From: [REDACTED]
Sent: 03 April 2023 20:26
To: Planning
Subject: Planning Application 3/2023/0176

Planning Application 3/2023/0176
Proposed Extension to existing Outbuilding to form livestock enclosure
New Chapel House, Preston Road Longridge Preston PR3 3BL

From: [REDACTED]
Sent: 04 April 2023 14:03
To: Will Hopcroft; Planning
Subject: Planning Application ref 3/2023/0176

JOB NO 3345
DRAWING NO 010
REVISION
SCALE As indicated @ A3

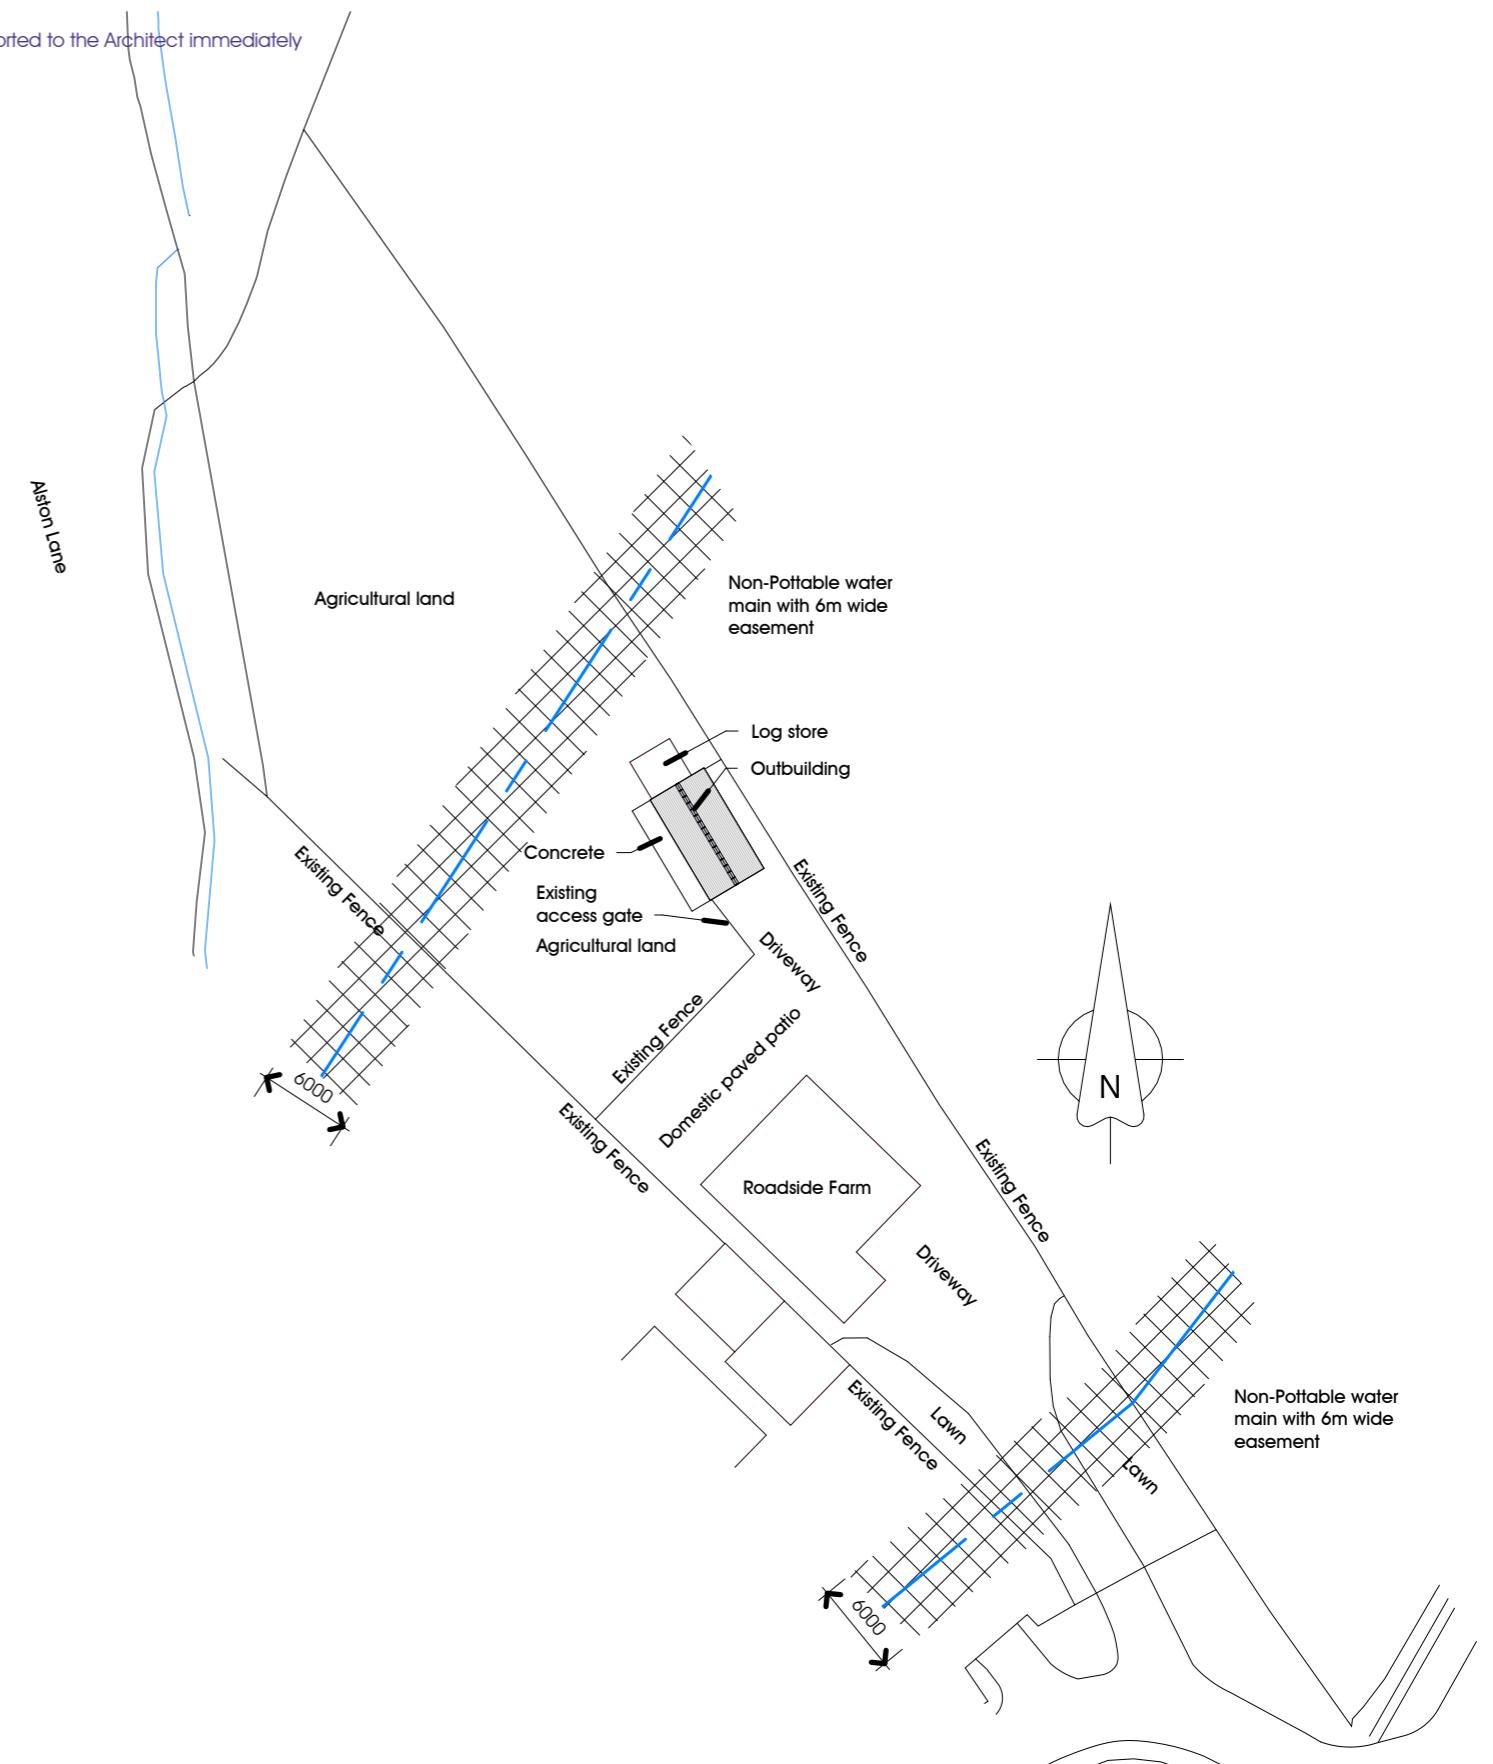
Plan 010 does not reflect all the buildings and structures existing on the applicants land currently and this is believed necessary to appreciate the bigger picture of the Applicants intentions going forward. A site visit by your department would be beneficial to appreciate those concerns.

2. The potable water easement indicated to the frontage of the property we believe is wrongly located, whilst this does not affect this application the applicant / agent should be aware of its correct location as this affected the siting of the garages for the adjacent properties as shown on application 3/2013/0274. The siting of the rear water main should also be verified.

JOB NO 3345
DRAWING NO 030
REVISION
SCALE 1 : 100 @ A3

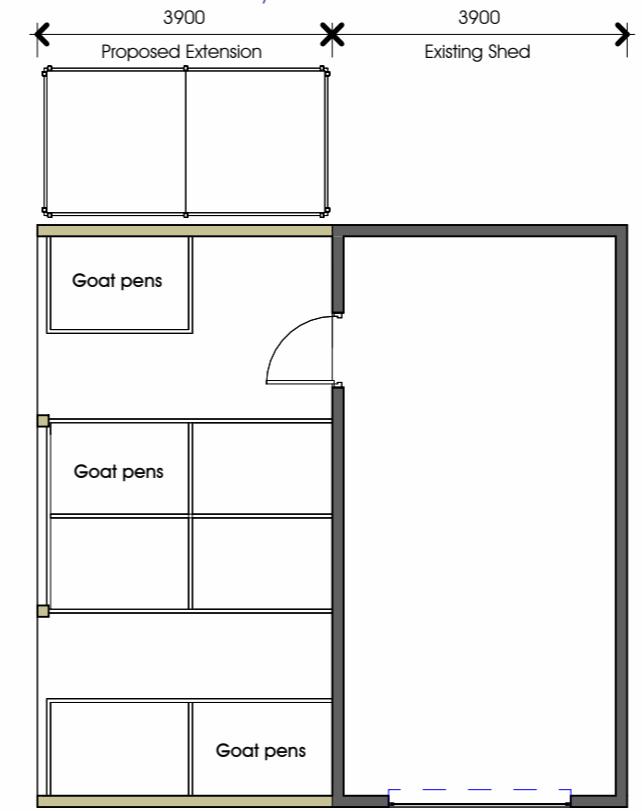
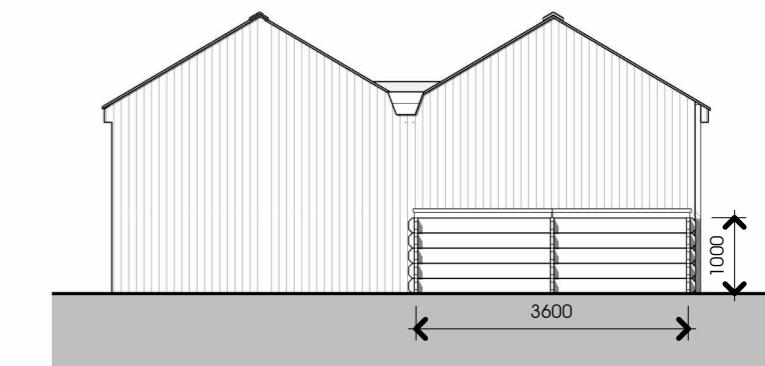
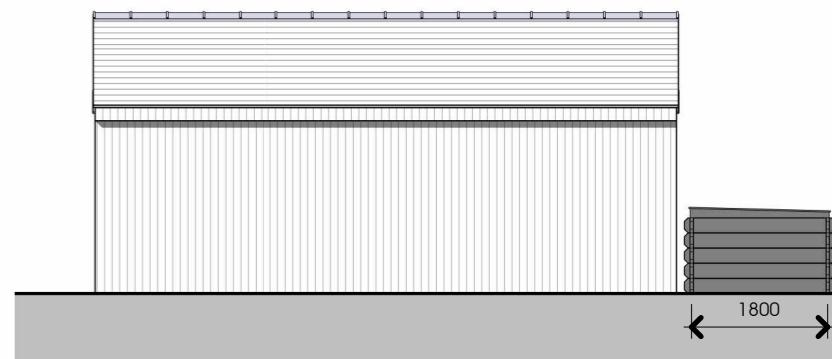
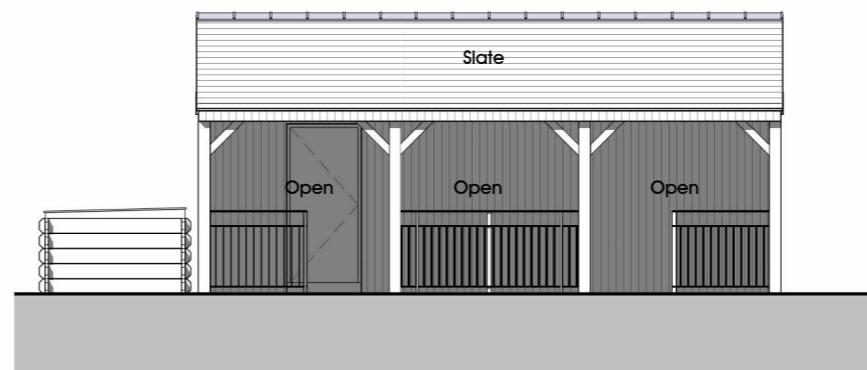
6. It is our understanding that the keeping of livestock, stated as goats at this time need shelter from wet weather but also the sun, whilst the plans indicate the west flank to be open, this elevation would be subject to rain and the sun due to its aspect and therefore does not provide suitable accommodation in our view for the purpose it is intended.

7. The configuration of the building and valley roof is out of keeping with buildings in the vicinity, and may well be a maintenance issue to the applicant going forward.
